From: Kate Giddings
Sent: 20 May 2019 13:20
To: Anita Gardner
Cc: Planning.Responses; Anna Appleton
Subject: LU/126/19/PL - 25 River Road, Littlehampton, BN17 5BZ

Further to the above application, please may EH make the following comments:

PROPOSED DRAWINGS:
Terminus Place
First Floor Layout

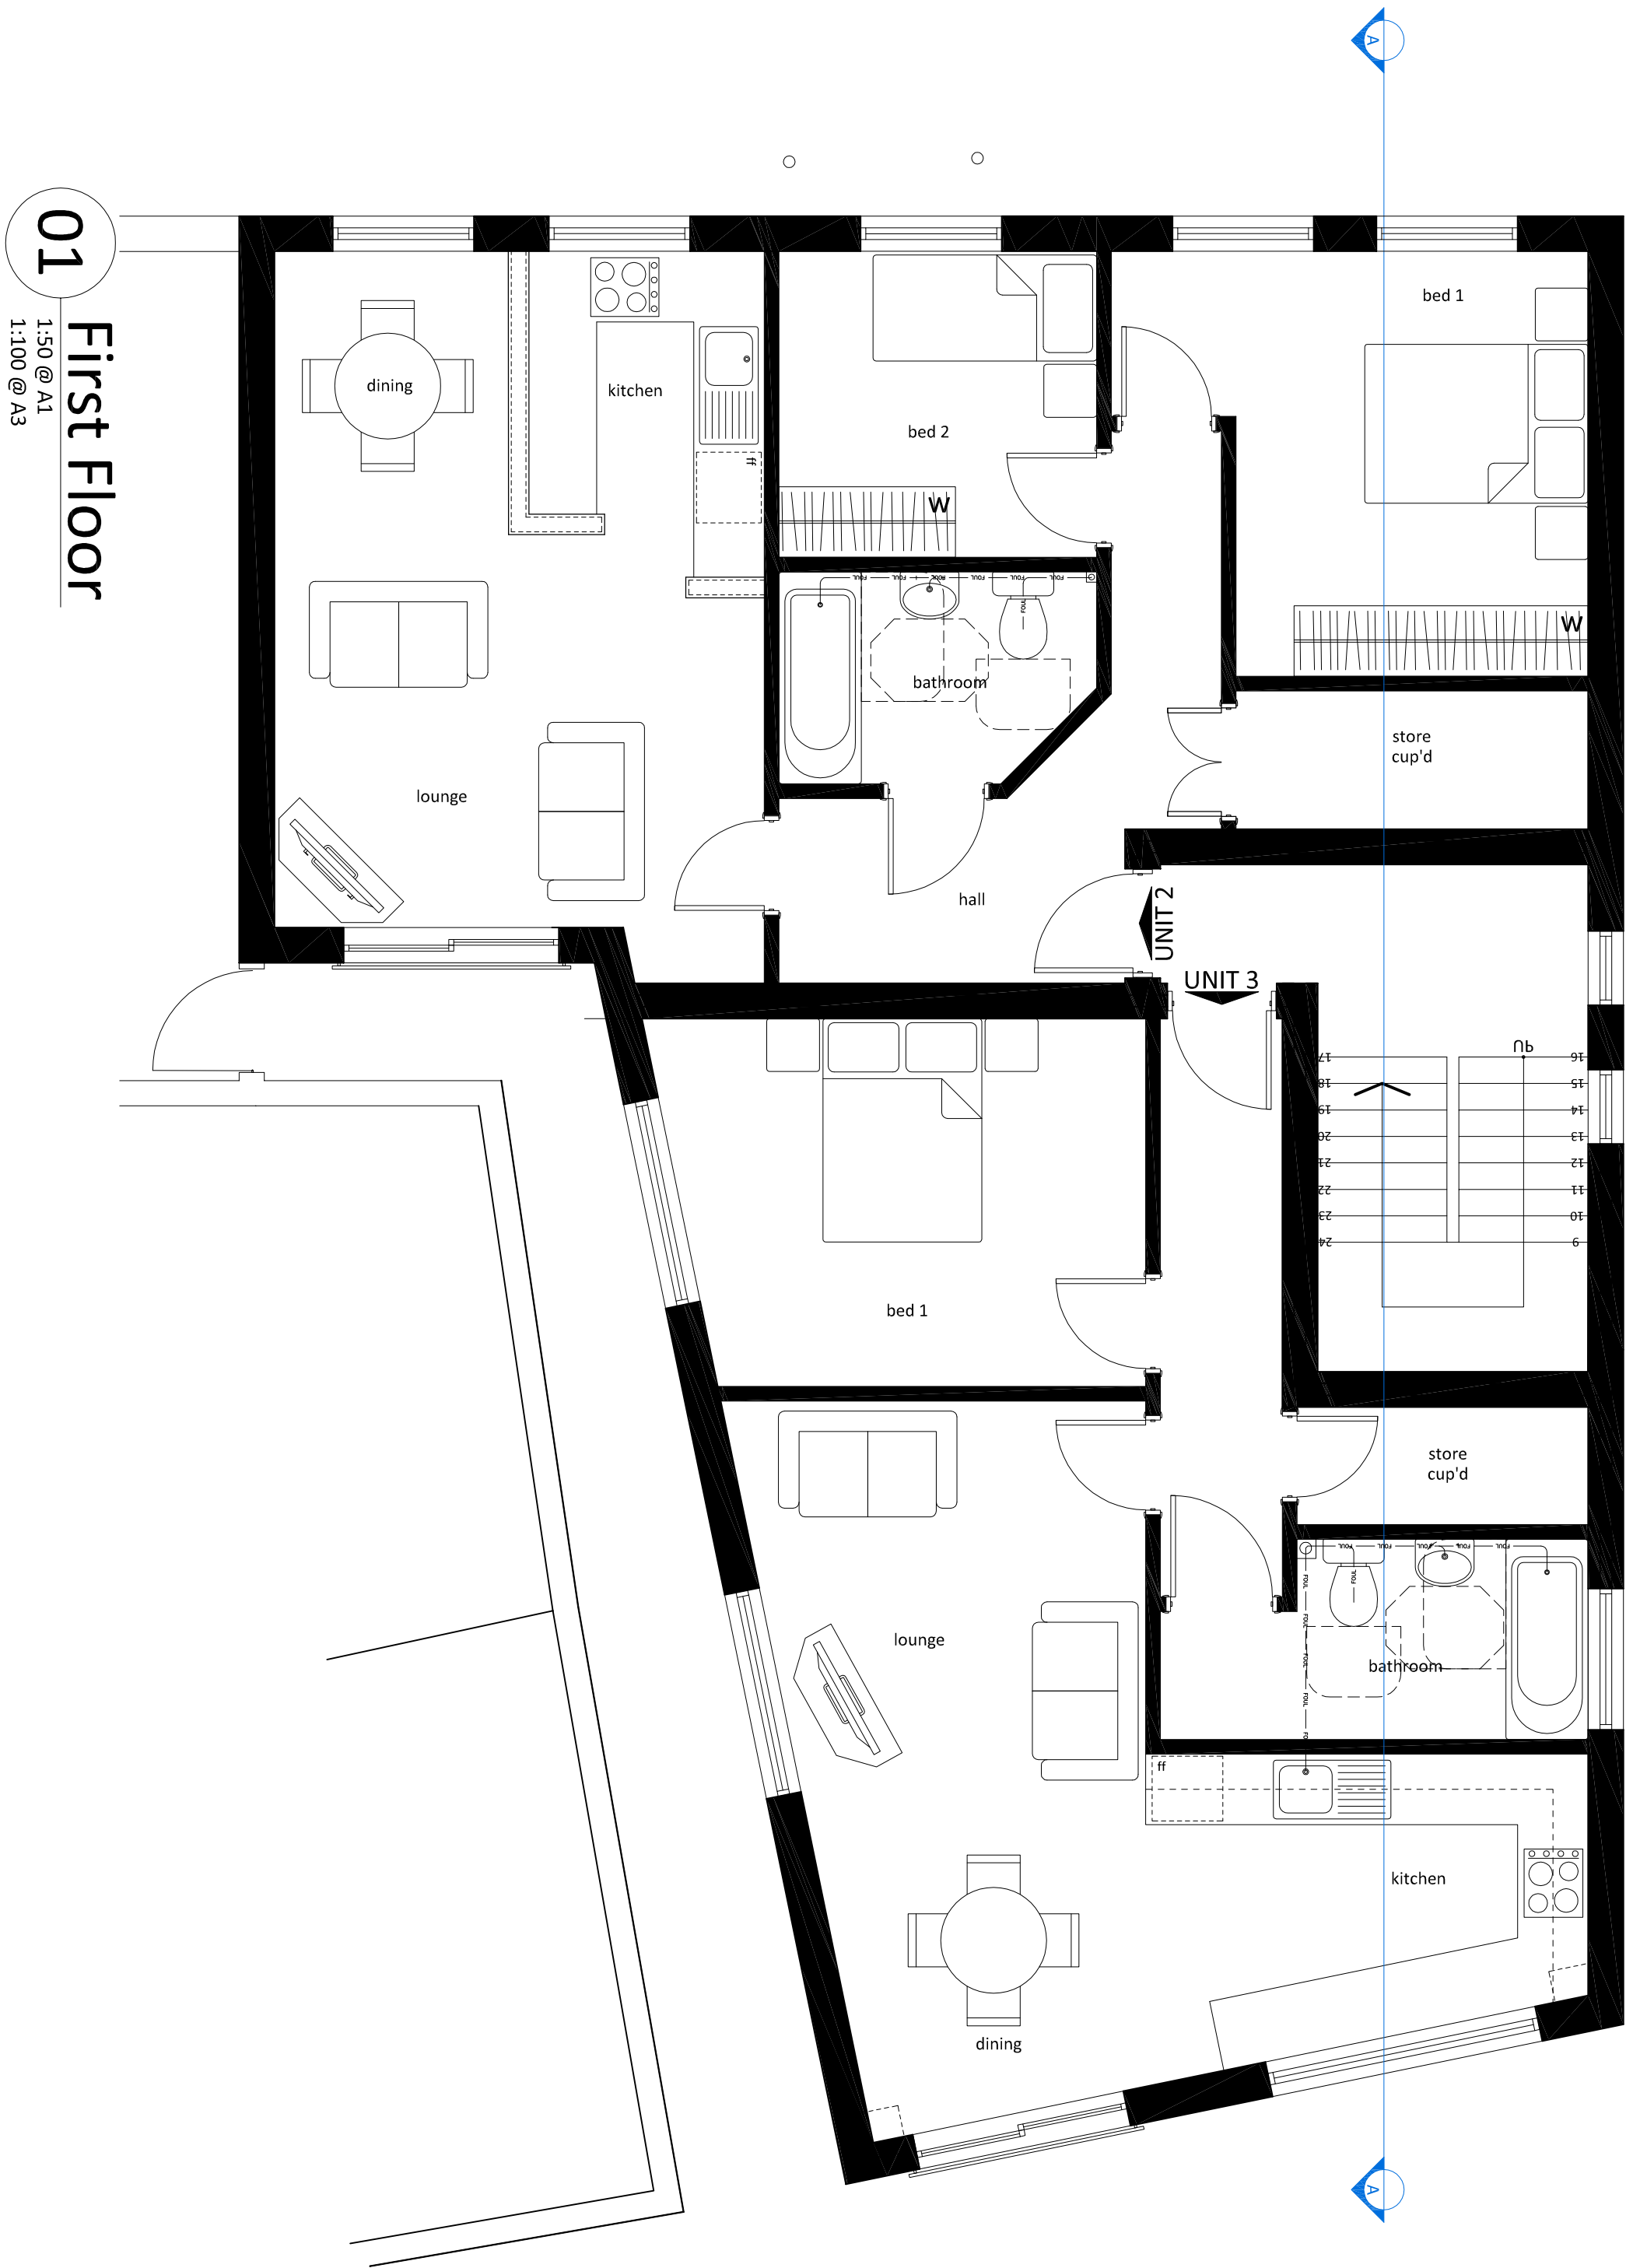
Please may the applicant/agent also confirm how external noise from the wheelie bin area will be managed with regard to the main bedroom of Unit 1. In addition, how will internal noise be managed between the bedrooms of Units 3, 5, 7 and the hallways of Units 2, 4, 6, respectively?
